From: Amanda Scholes on behalf of Planning.Responses
Sent: 01 July 2020 09:39
To: Planning Scanning
Subject: FW: F/9/20/DOC FW: 23314 Wick Farm, Ford - Arun Drainage Response
Attachments: Althon R10CA Headwall + 400mm Toe + Hinged Cranked grating.pdf; Althon R20B_Datasheet_and_Installation_Guide.pdf; 10_D_Site Layout.pdf; 21_D_Drainage and Levels - 1 of 6.pdf; 22_D_Drainage and Levels - 2 of 6.pdf; 23_D_Drainage and Levels - 3 of 6.pdf; 24_D_Drainage and Levels - 4 of 6.pdf; 25_A_Drainage and Levels - 5 of 6.pdf; 26_A_Drainage and Levels - 6 of 6.pdf

Please see the string of emails below plus the additional information attached that you requested for the glasshouse & reservoir development at Wicks Farm, Ford.

From: Mark Wren <[redacted]>
Sent: 24 June 2020 14:50
To: Stuart Magowan [redacted] John Hall [redacted]
Cc: Andrew Hawes [redacted] Stuart Lever
[redacted]; Lee Clarke <[redacted]>; David Moore
[redacted] Steve Burgess <[redacted]>; CEP | Reception
Subject: RE: 23314 Wick Farm, Ford - Arun Drainage Response

Installation Guidelines

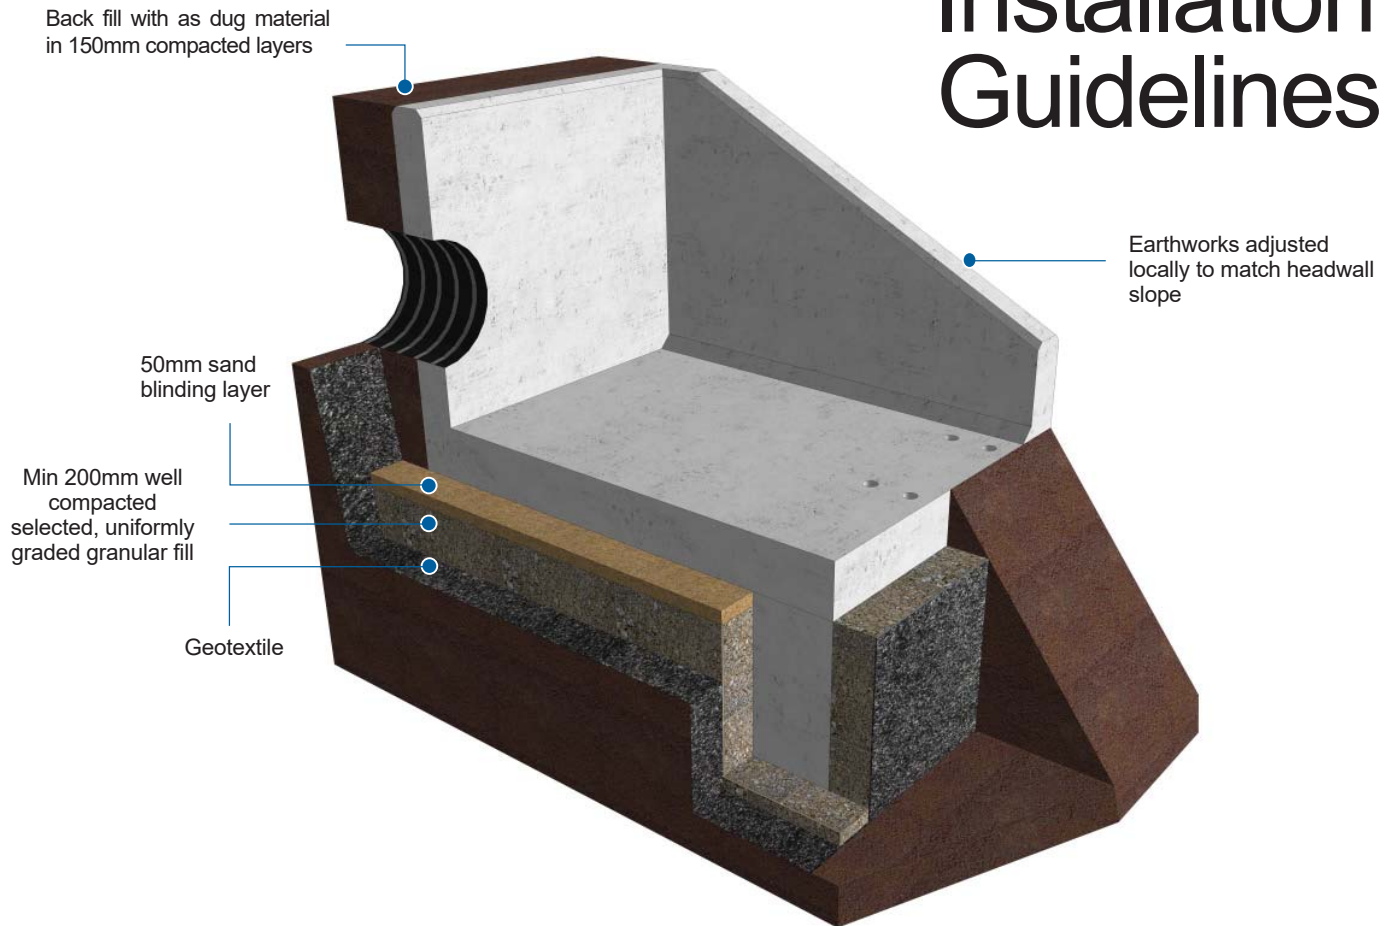
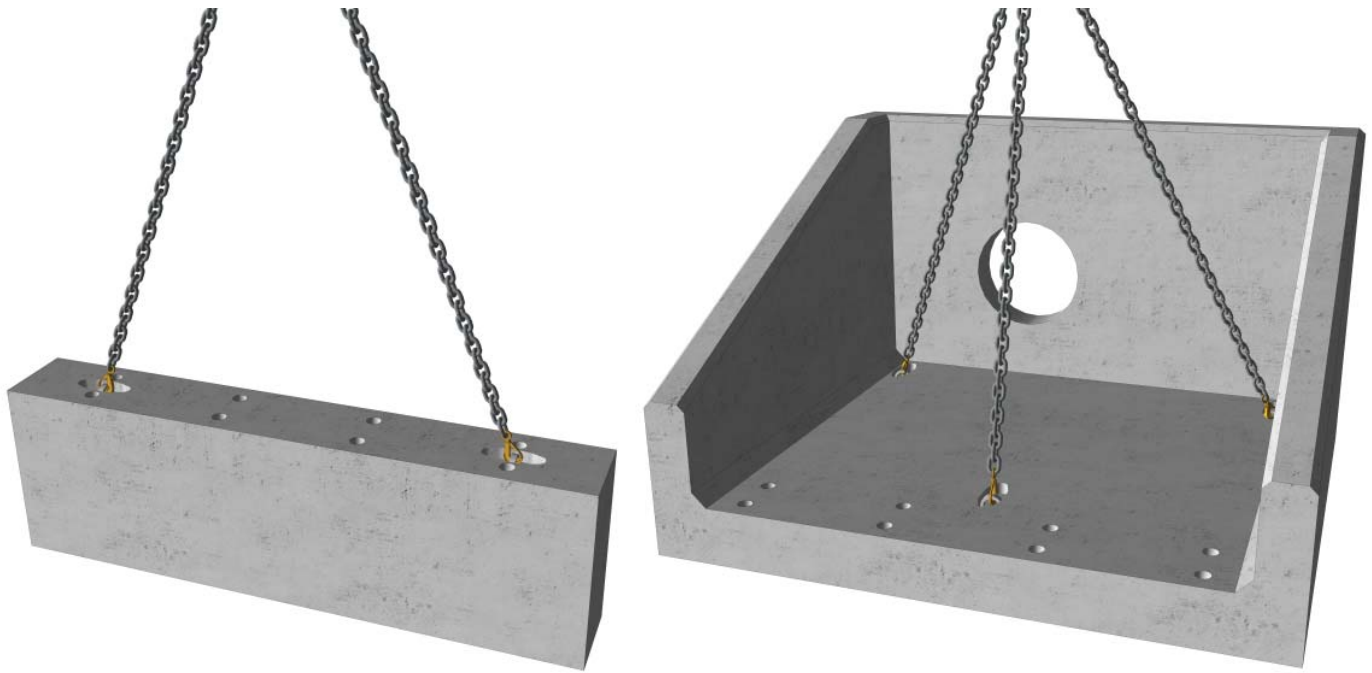
9. Provide construction details for all prefabricated headwalls. All 450mm pipe exits/entries to be fitted with suitable cranked grille.

See Althon detail 'R10CA Headwall + 400mm Toe + Hinged Cranked grating' for all headwalls serving 450mm pipes.
We have provided further details for the headwalls forming part of our design works into and around the southern boundary swale and pond.
